Arun District Council
Arun Civic Centre
Maltravers Road
Littlehampton
West Sussex BN17 5LF
Planning & Building Control General Enquiries
Tel: (01903) 737756 Fax: (01903) 730442
Dx: 57406 Littlehampton
Minicom: 01903 732765
e-mail: planning@arun.gov.uk
website: www.arun.gov.uk/planning

Application No: FG/114/21/HH
Site Address: 23 South Drive Ferring BN12 5QU
Description of works: Extensions and internal and external remodelling of existing dwelling to create a 4no. bedroom dwelling with double garage including single storey rear extension, replacement and reformation of roof to create second floor accommodation with rear balcony, associated landscaping.

Thank you for your internet representation made on 6th August 2021 which has been recorded as an objection with the comments as follows:

Street Scene Elevations -
Existing & Proposed

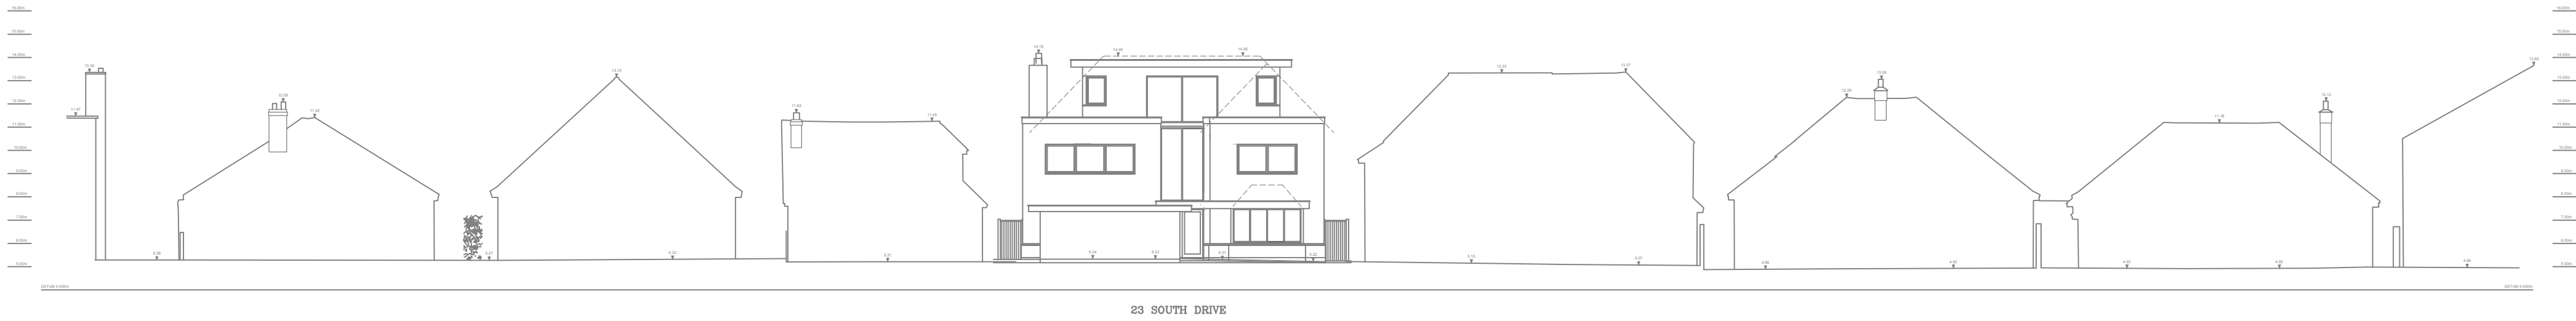
This application if approved would, in my view, change the overall "street scene" in this area in a very negative way.

The change of this existing property from a pitched roof structure to a flat roof block type development will produce a dominating and overbearing structure which will be out of character with this area.
